Submission re MP 08 0191 Port Kembla Demolition Project

***Evacuation Management Plan: 200M Stack Demolition
Revision 1: 9 October 20134.***

Traffic Management Plan

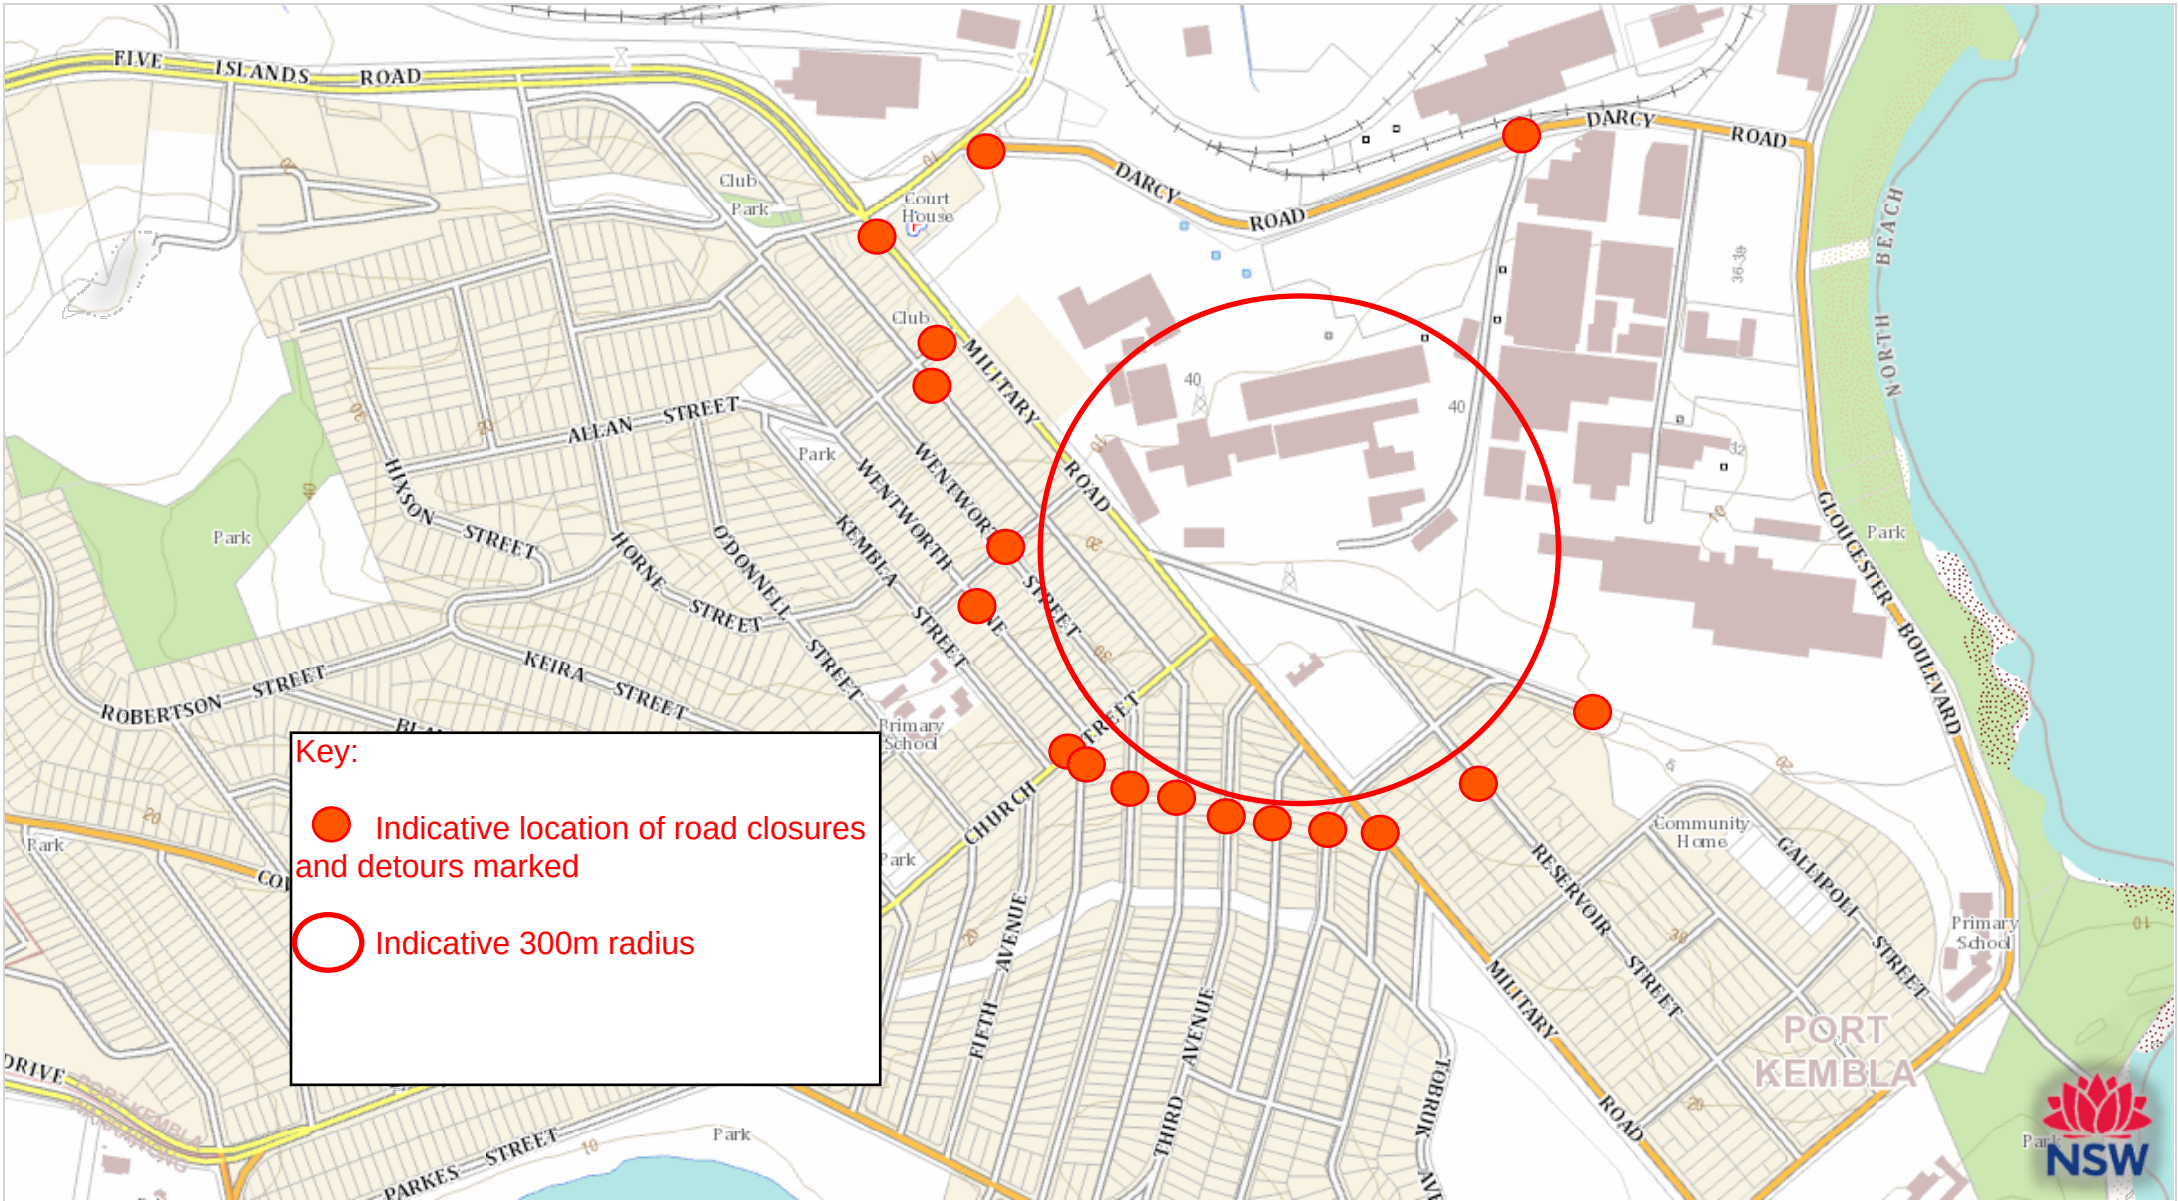
Many errors appear in the maps being used with roads inserted that have never existed and other roads that are relevant or missing and should be there.

I live at _____ and I will have to access _____ property via Wentworth Lane and Sydney Place (when Church Street is closed). However the maps don't even show Sydney Place and there are no DETOUR signs marked to close the southern end of Wentworth Lane. This leaves my property open to easy public access even though I am in the Exclusion Zone and I will be required to leave my property for safety reasons. If the lane does eventually get closed then it can still easily be accessed by residents in Fifth Avenue (who are not in the EZ) using their rear gates.

Will these maps be corrected and information used be reviewed? I am happy to share my 69 years of local knowledge to assist.

- F. Not all access roads are shown on their maps in their documents supplied on 25th October and therefore not all access to the Exclusion Zone is shown to be blocked.

THIS IS NOT
A T INTERSECTION

WENTWORTH LANE STH
NO SHOW OR WITH
ANY ROAD CLOSURE

THIS LANE HAS
NEVER EXISTED

THESE
ARE HANDLOCKED
WITH NO DETOUR

BOTH
ARE IN TOTALLY
DIFFERENT STREETS

SYDNEY PLACE
NOT ON MAP

BUT IS ACCESS
IN EXCLUSION ZONE

• WHERE IS DETOUR? TO BE

NOT ON THIS
MAP EITHER
